Letter No. C4/13321/97.

Sub: CMDA - Planning Clearance - Proposed
additional construction of Elementary
School by Local Body at S.No.259,
T.S.No.12, Ward 'F' of Alandur village
- Approved - Regarding.

2. Two copy/set of approved plans, numbered as Planning Clearance No. C/PC/24592/6/97, dt. 16.7.1997 is sent herewith. The Planning Permit is valid for the period from 16.7.1997 to 15.7.2000.

ALANDUR MUNICIPALITY
 PLAN SHOWING THE
 PROPOSED ADDITIONAL
 SCHOOL BUILDING AT
 VANVAMPET MUNICIPAL
 SCHOOL, ALANDUR

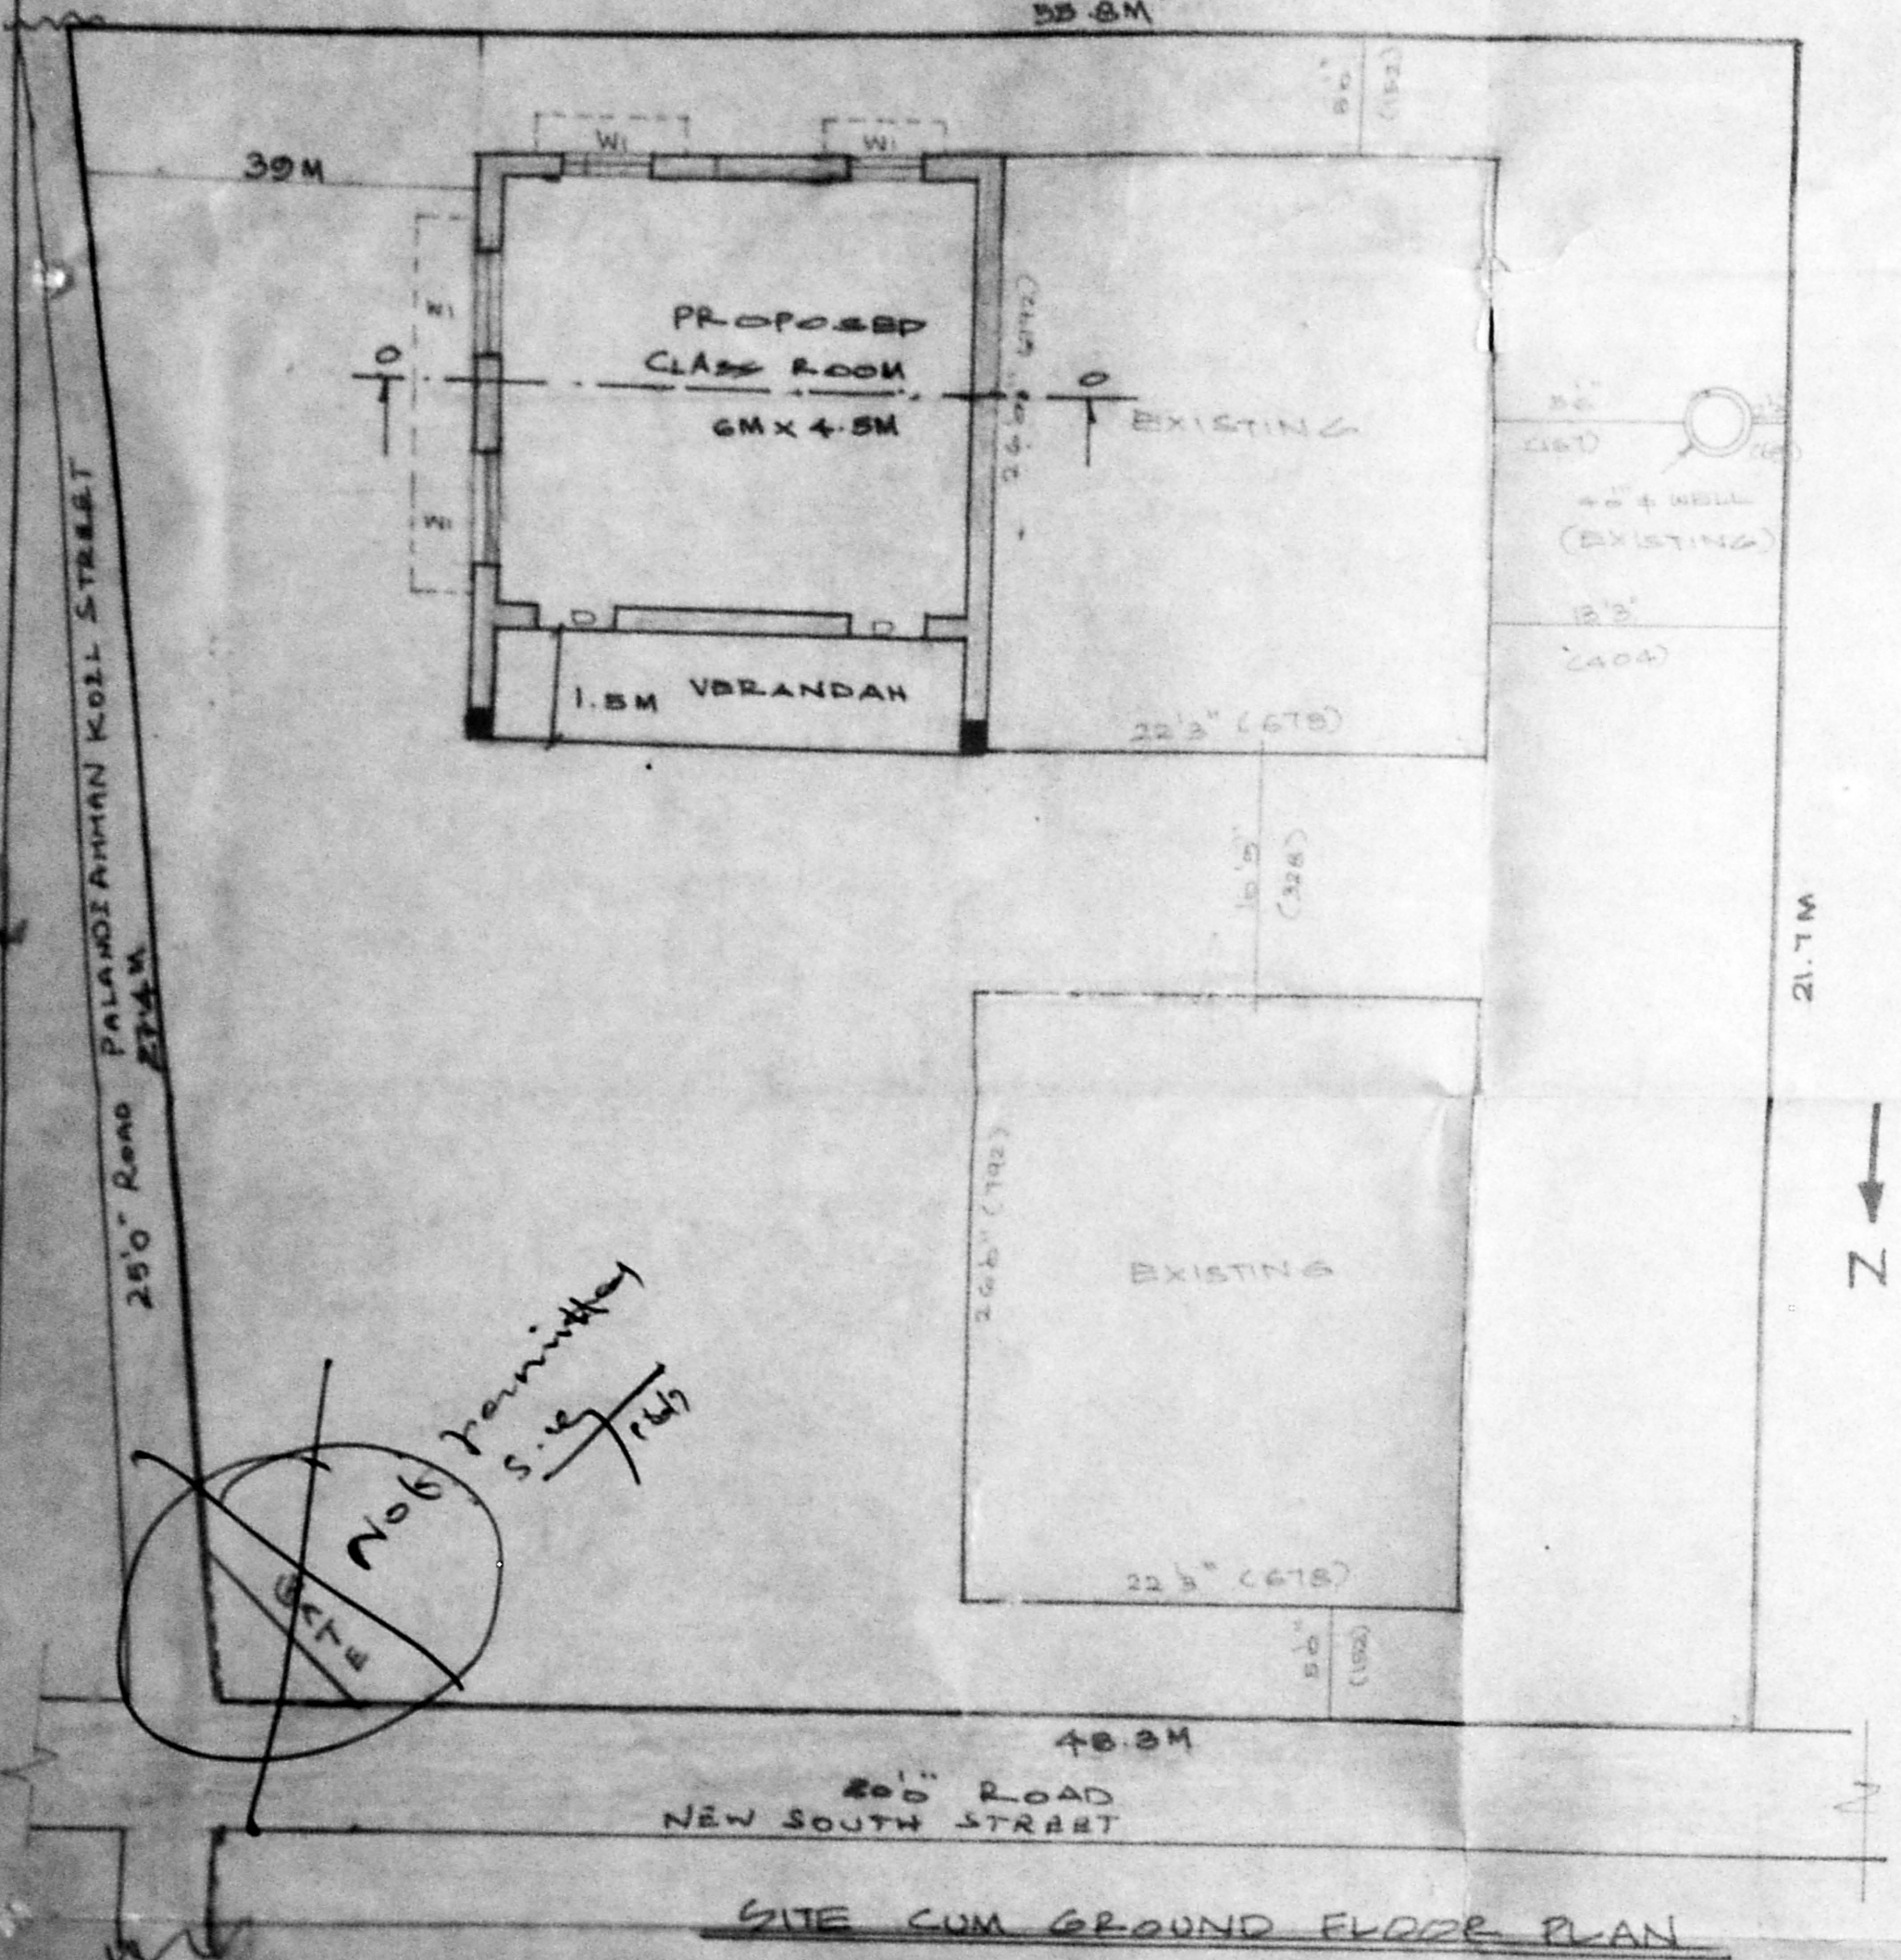
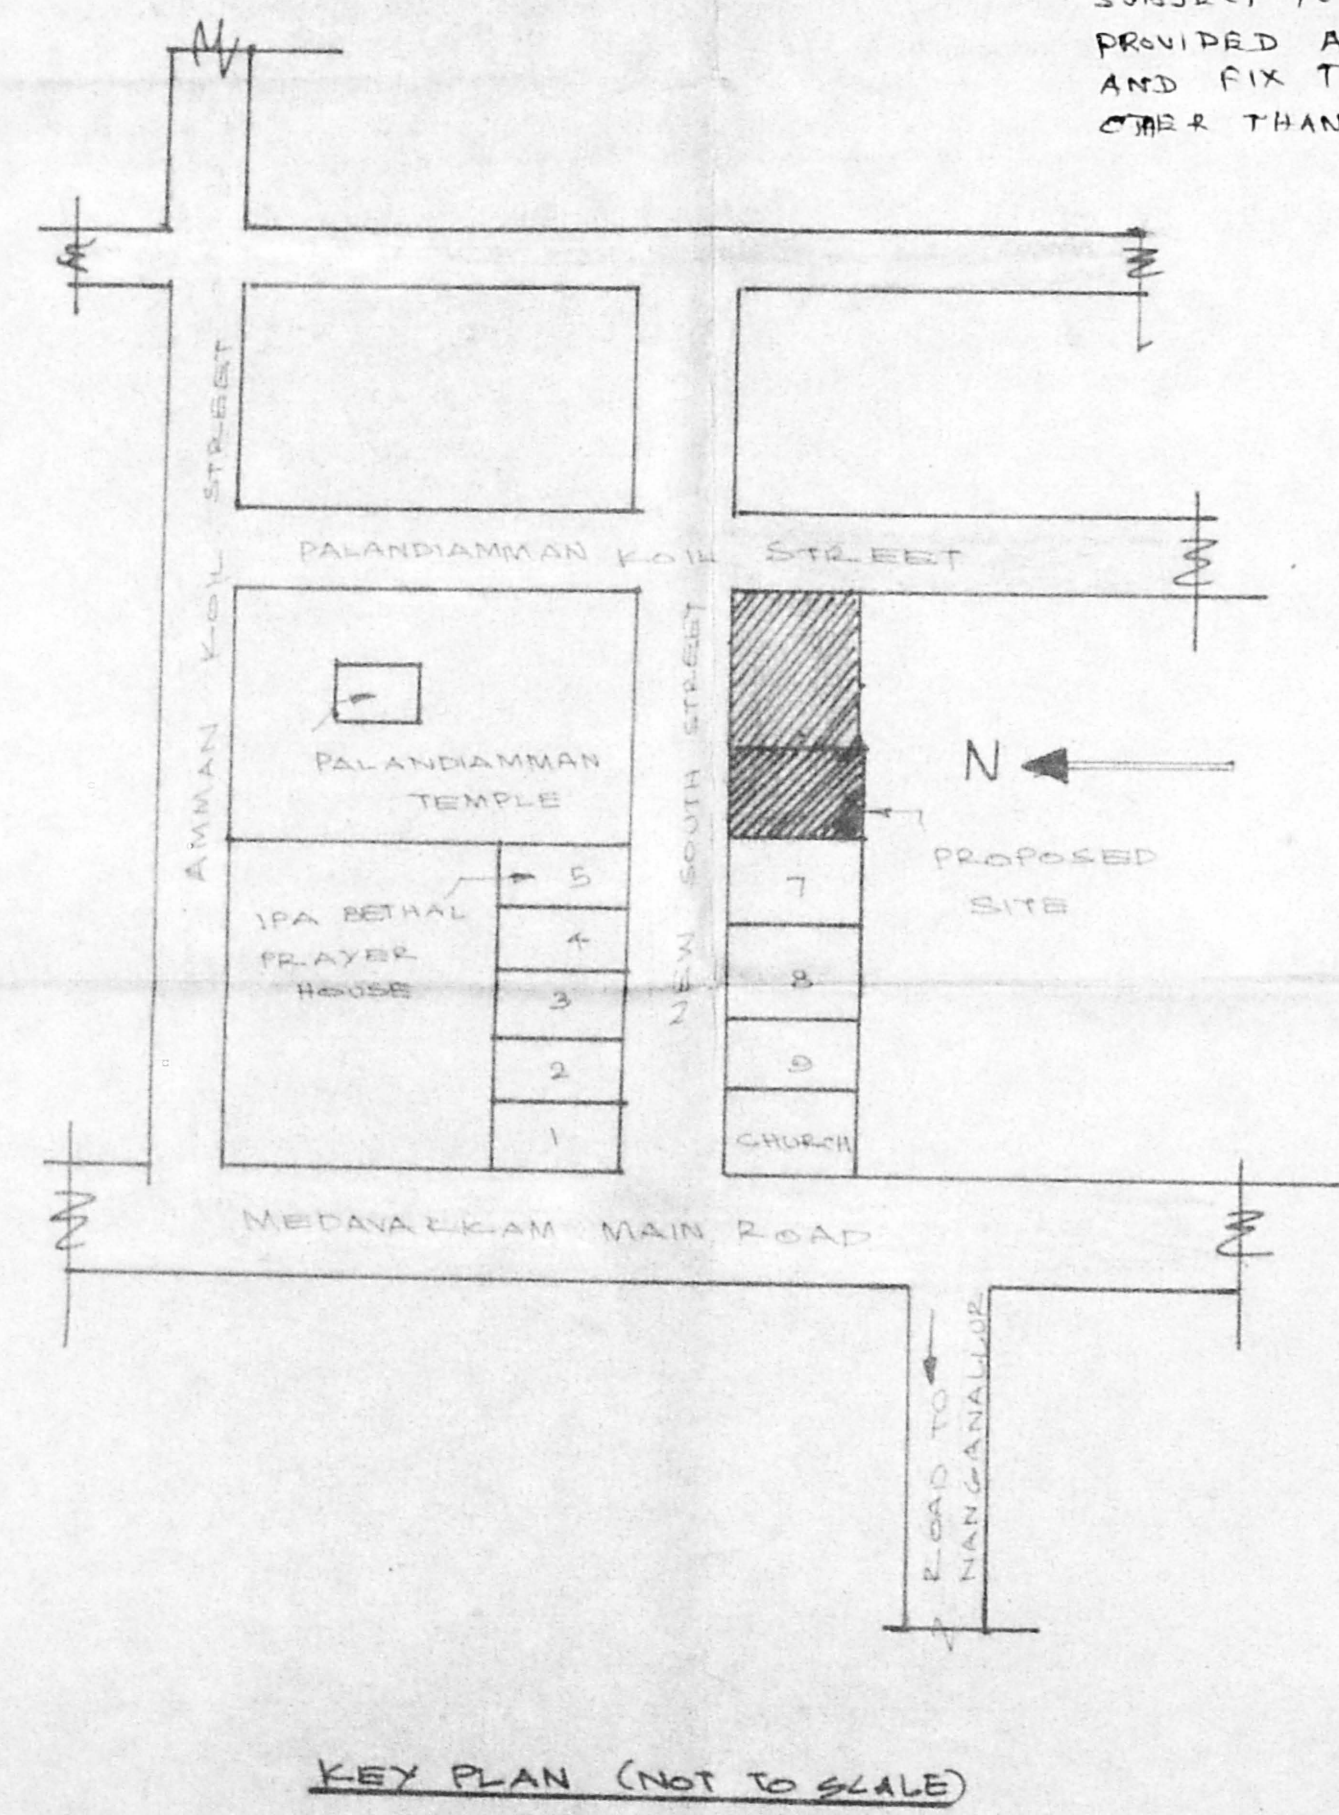
The Planning Clearance application received in the reference cited for the additional construction of Elementary School by Local Body at T.S.No.259, T.S.No.12, Ward 'F' of Alandur village has been approved subject to the condition that the gate at splay should be changed to any other convenient place during the construction. Since the gate at splay is not permissible as per DCR.
